Re: Project# SHL23-025 & SEP23-010
Review Type Planning
Project Address 4452 Ferncroft Rd, Mercer Island, WA 98040

Below are our responses to the correction. Your original comments are in italics, followed by our responses in plain text.

**Sheet 2 of 9**   **Date:** 4/25/2023  
**Rev One:** 8/25/2023

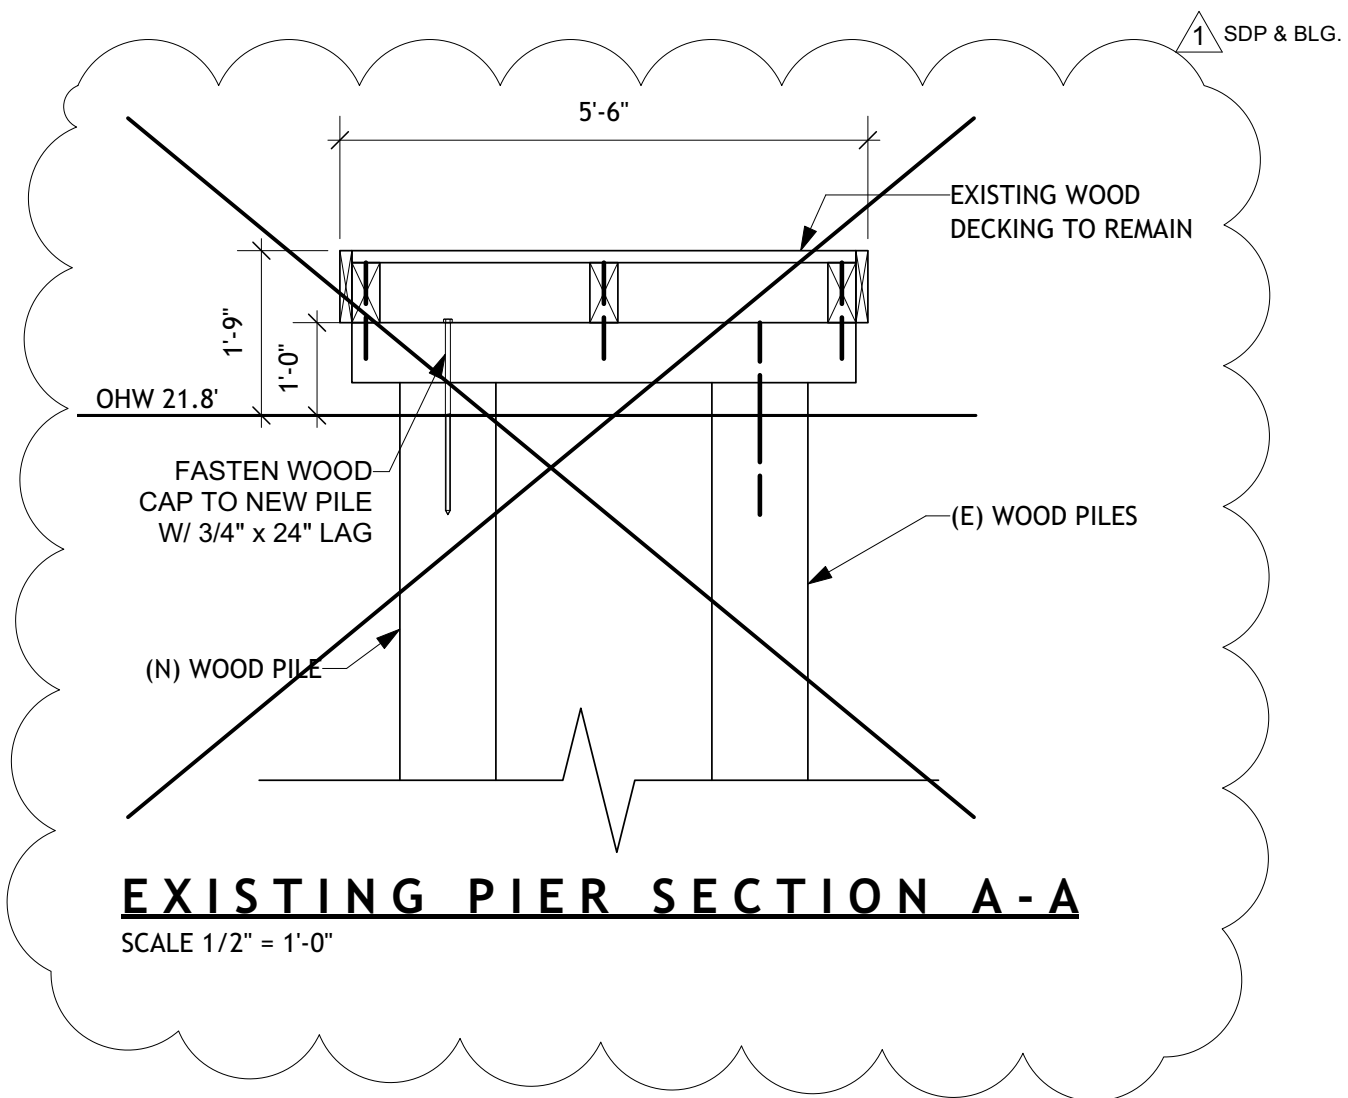
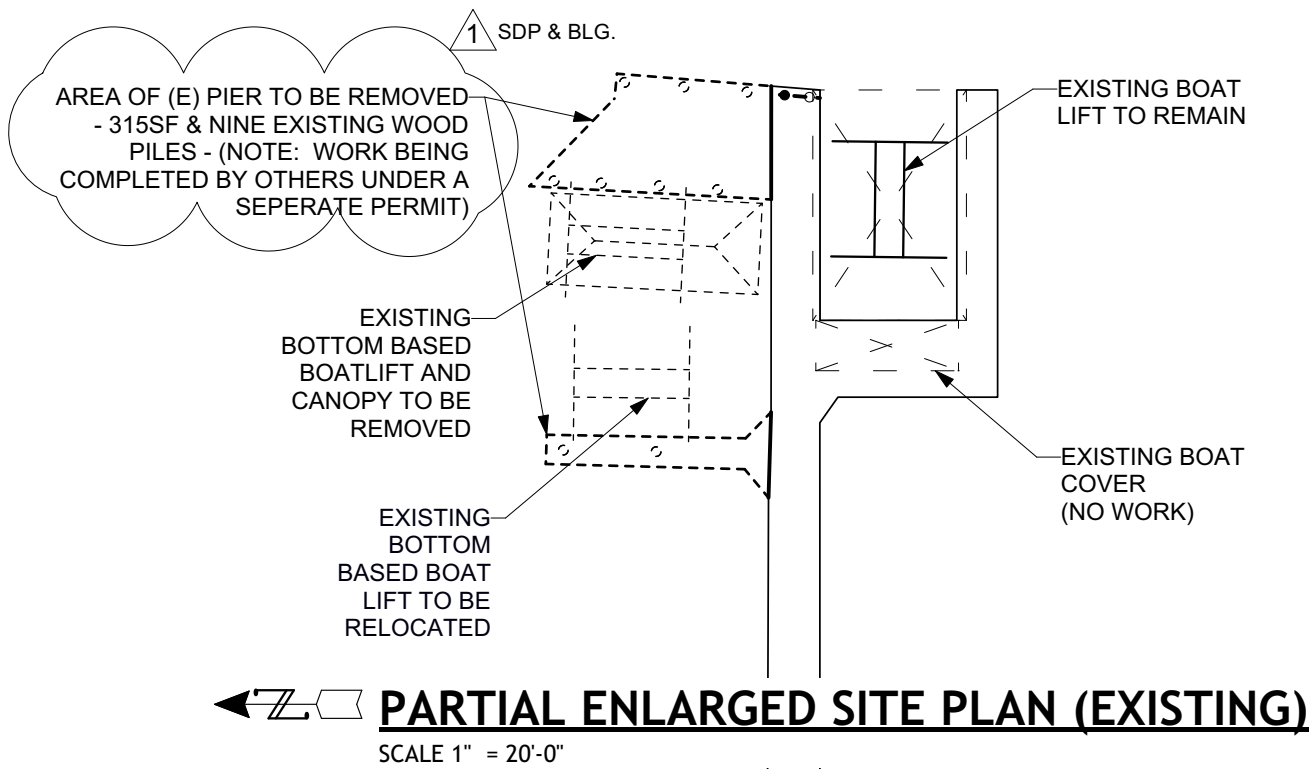
2. ***The Shoreline Setback Agreement states that “Evers” has agreed to obtain separate permits to rebuild and/or restructure the dock entirely on the Evers Property. Based on the application materials, it appears that there will be a new pile driven on the Evers Property to support the restructuring of the existing dock. Please provide documentation that this work is authorized by the Evers Property owner to be performed under this Shoreline Substantial Development Permit.***

The drawings have been revised showing the Ever’s work as being completed by others. The Ever’s permit will now be handling all structural work including any necessary pile driving.
